# **Lime Down**

## Solar Park

## **Volume 3, Appendix 1-2: Scoping Opinion Response Table**

**Planning Inspectorate Reference: EN010168**

Title: Figure 8-8 Bare Earth
Zone of Theoretical Visibility (ZTV)
of the Full Scheme

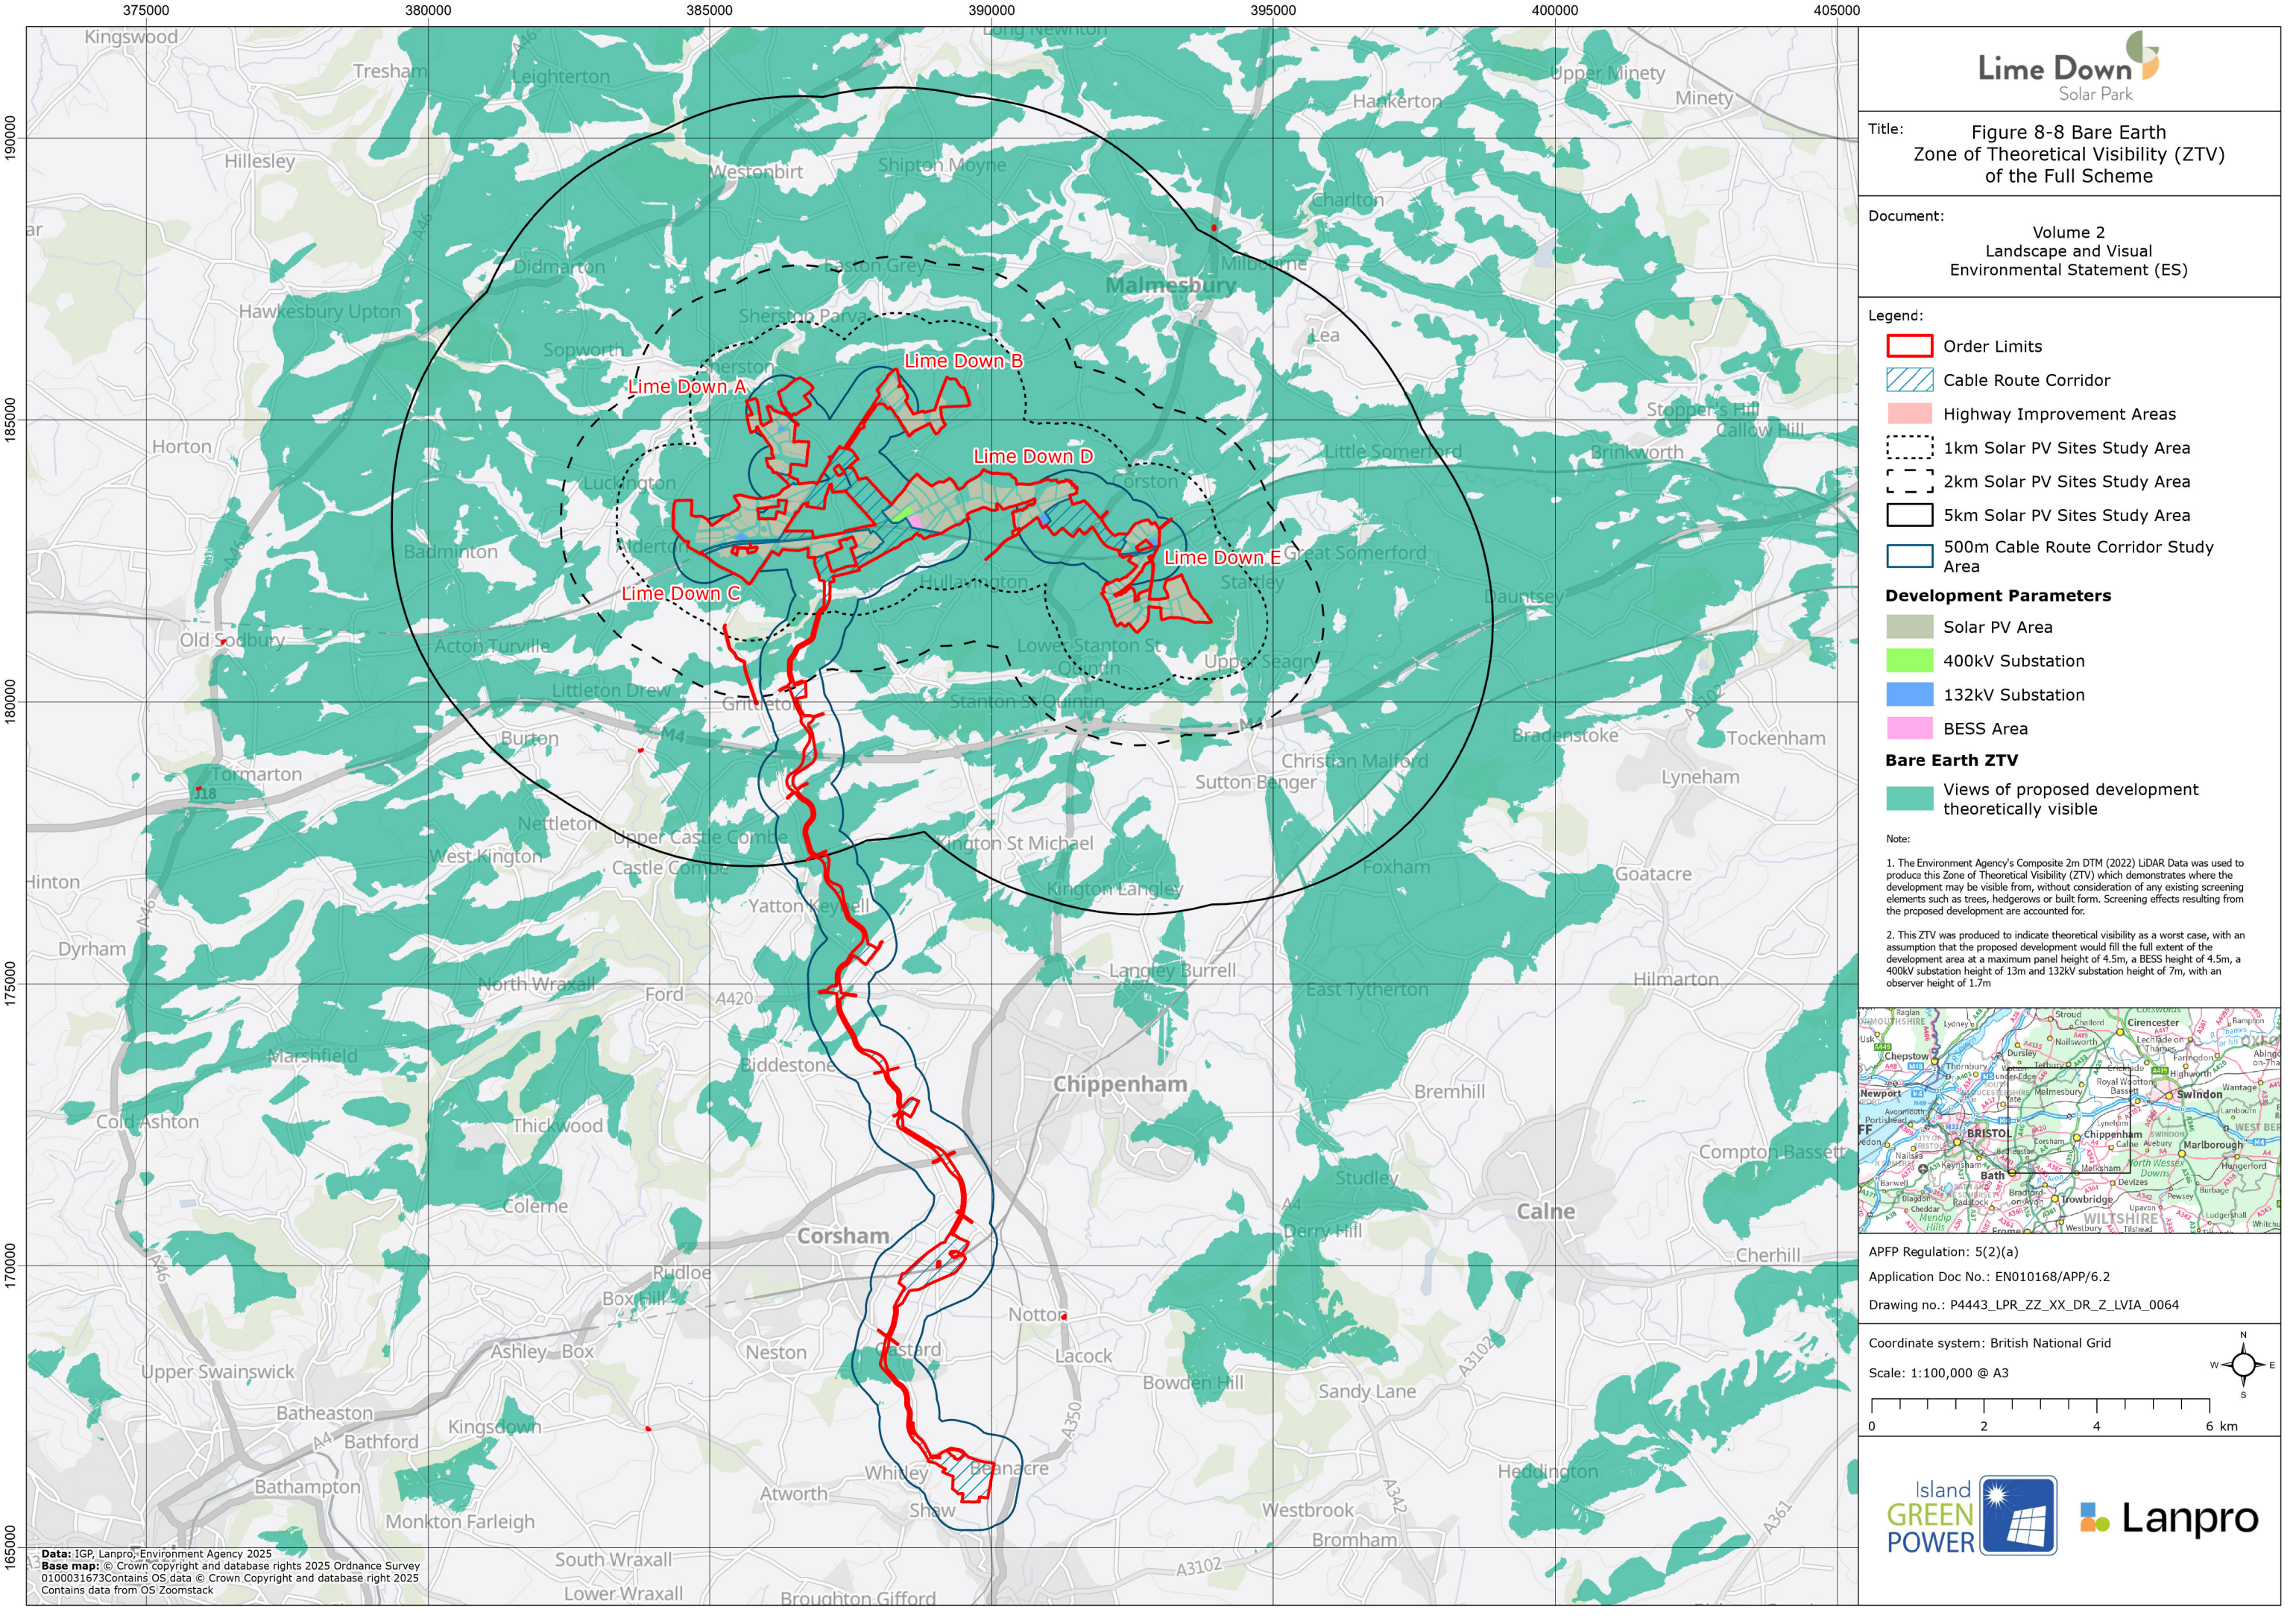
Planning Inspectorate	Landscape and Visual: ZTVs	The Scoping Report states that the ZTVs were based on the Scheme at 4.5m above ground level and that separate ZTVs will be provided for the substations once locations have been established. Table 4.1 of the Scoping Report states that the anticipated heights of the 400kV and 132kV substations are 13m and 7m respectively. Consequently, the ZTVs may not be representative of the full extent of visibility.  In order to demonstrate that the full extent of the Proposed Development has been assessed, the ZTVs should be based on maximum design parameters to be permitted by the DCO. The ES should clearly evidence and justify the final extent of the ZTVs and ensure that any assessment of significance is based on this maximum extent	The suite of ZTVs in <b>ES Volume 2, Figures 8-8, and 8-9 [EN010168/APP/6.2]</b> have been updated to include the 400 kV and 132 kV substations at heights of 13 m and 7 m respectively. The ZTVs and the assessment of significance is based on the maximum design parameters.
